The countryside charity
Oxfordshire

CPRE CHERWELL DISTRICT COMMITTEE COMMENTS ON OUTLINE PLANNING APPLICATION 23/03428/OUT – OS PARCEL 7921 SOUTH OF HUSCOTE FARM AND NORTH WEST OF COUNTY BOUNDARY DAVENTRY ROAD BANBURY

JOB TITLE		LAND AT M40 J11		CLIENT		GREYSTOKE	
DRAWING TITLE							
A361 ROUNDABOUT WITH SECONDARY ACCESS							
SCALE	DRAWN BY	DATE	DRAWING No	REVISION			
1:1000@A1	RM	04/12/23	23457-07-01GA	C

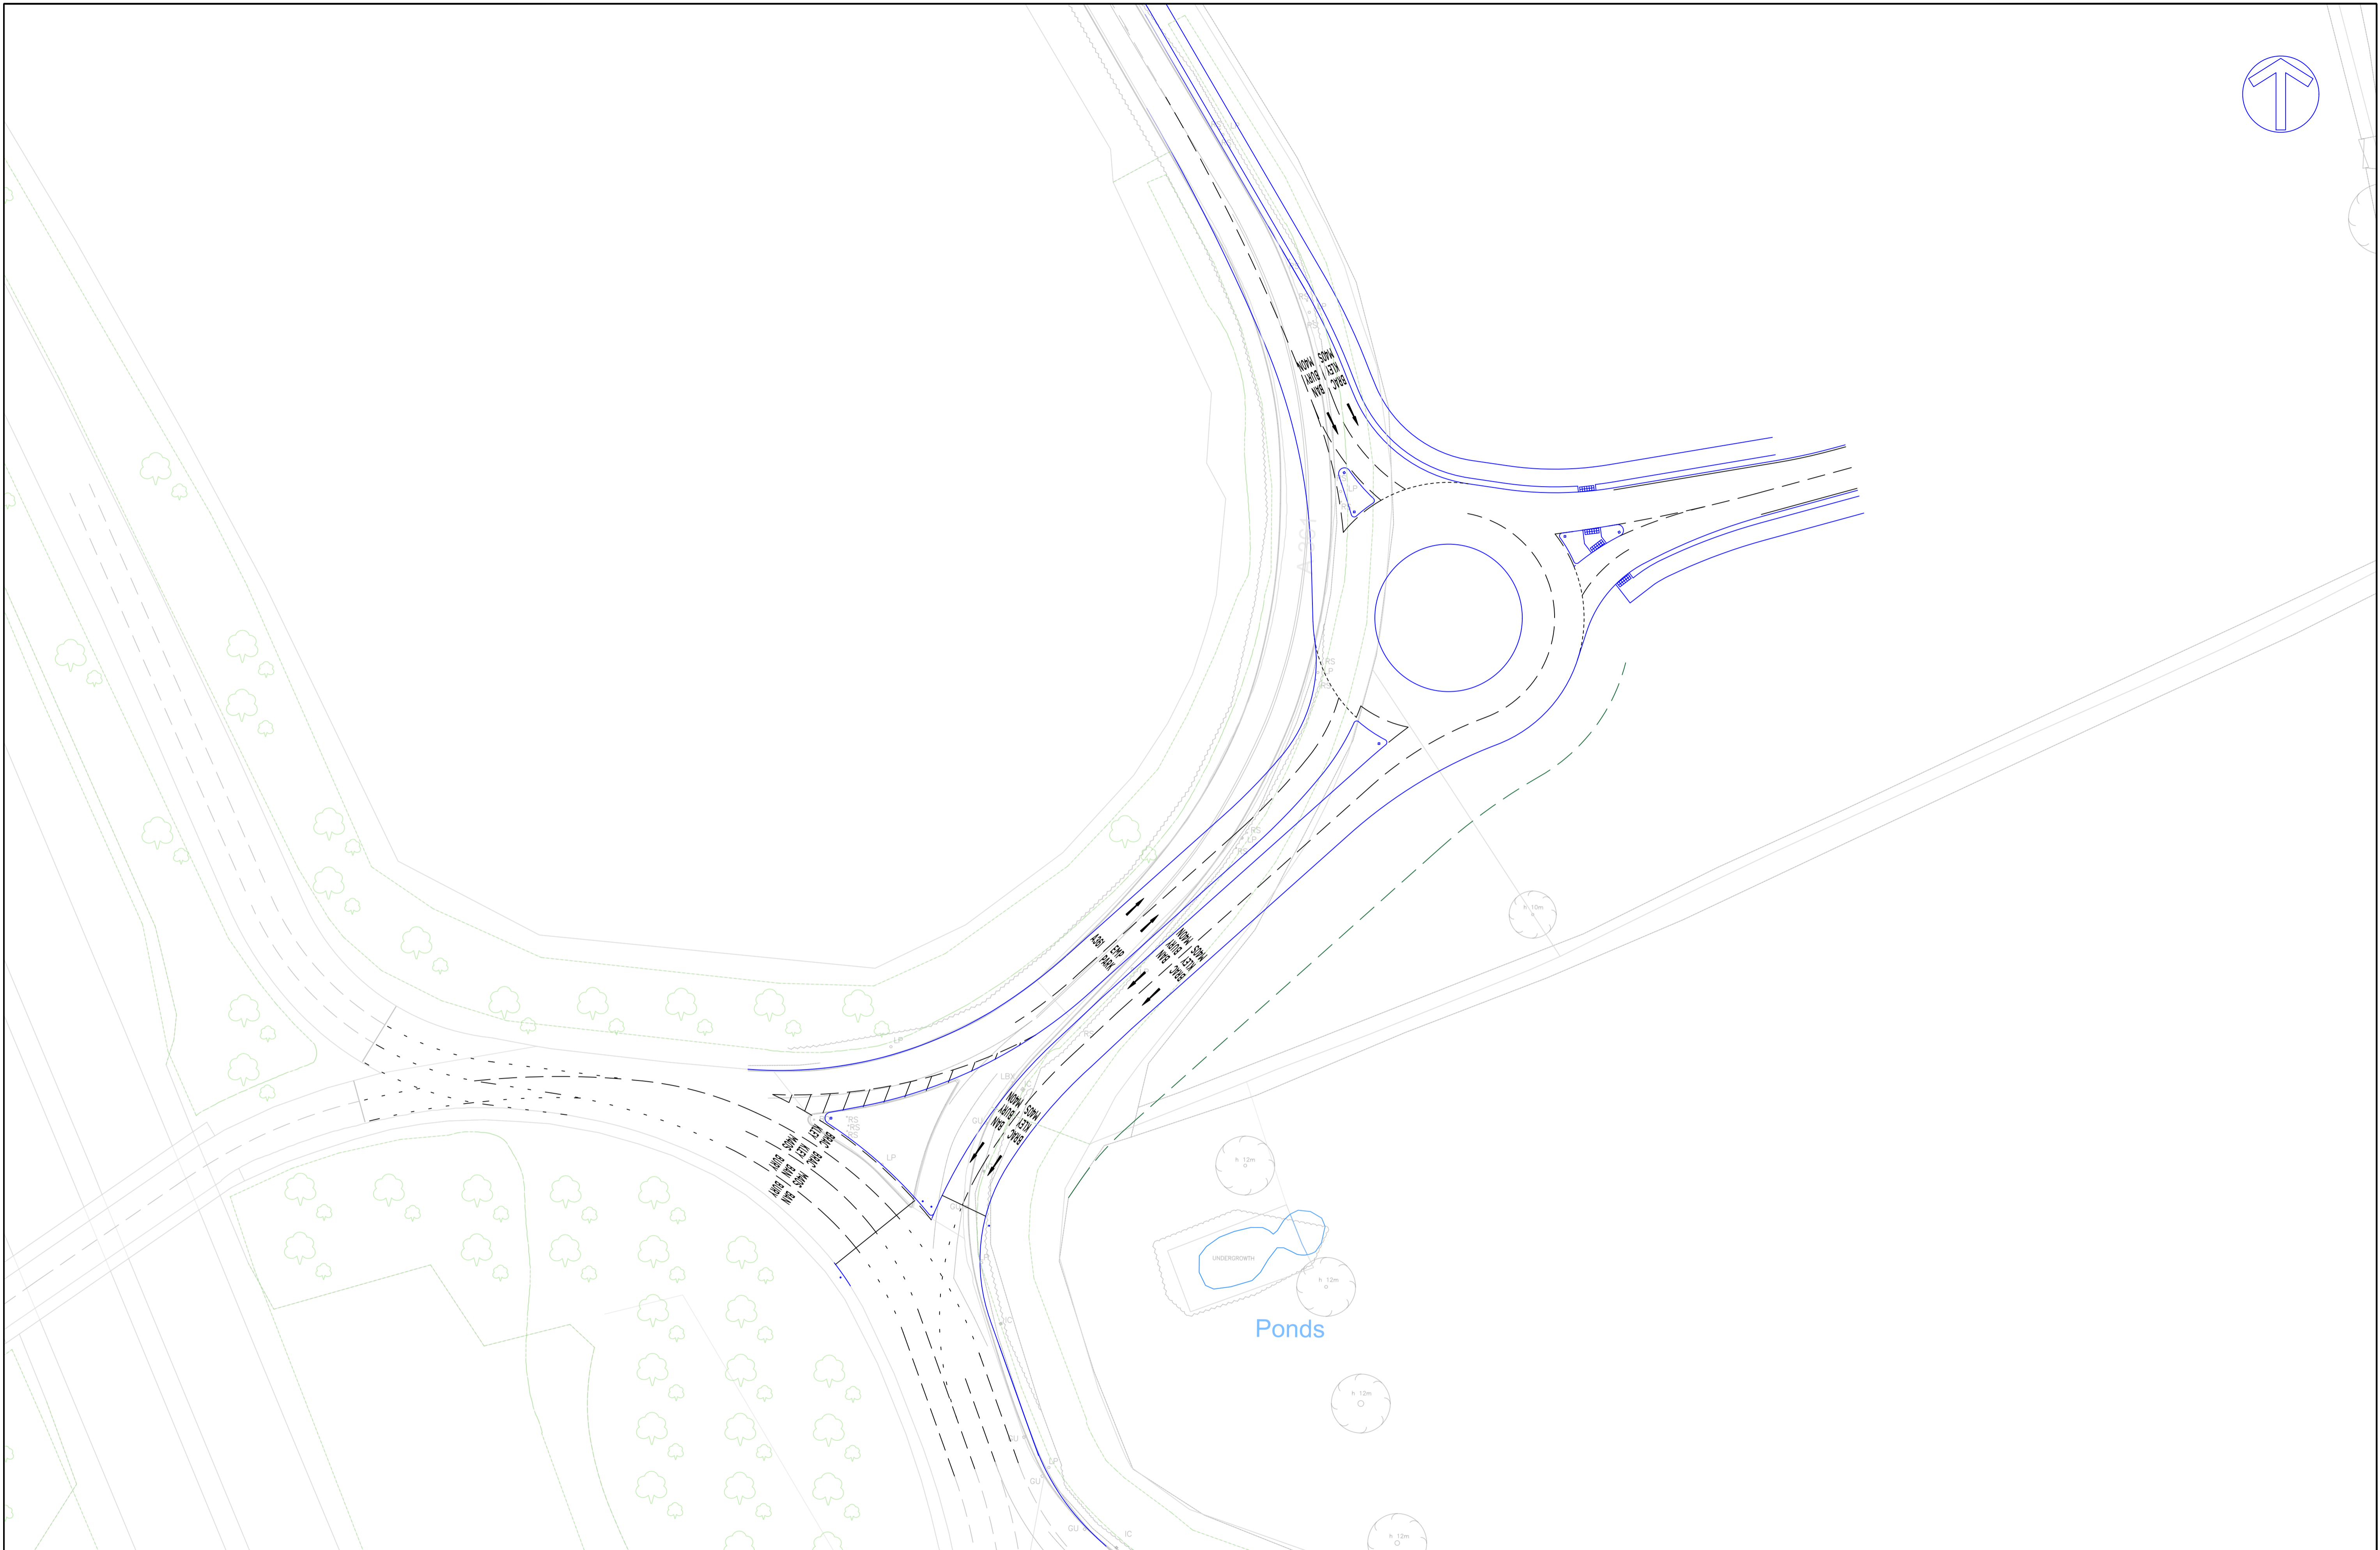
In their consideration of the original proposal, Oxfordshire County Council quite rightly suggested that the proximity of the proposed exit roundabout from the site at a distance of 100m from the J11 M40 interchange poses significant issues in terms of safety and traffic congestion at J11 and surrounding access roads. In conjunction with the extra traffic load anticipated from Frontier Park together with anticipated HS2 traffic, the extra traffic load from this proposal in the vicinity of the already heavily overloaded J11 would be unsustainable.

1. The major access point to the A361 would be within 100m of the M40 junction itself on a 90 degree curve.
2. Even without the wholly inappropriately sited roundabout there would be three entry and exit points to major warehouse on the A361 within a few hundred yards of the J11 of the M40 with one, at this stage, proposed to be on a tight curve. This can only represent a significant safety hazard let alone the significant potential for traffic build up along that stretch of road.
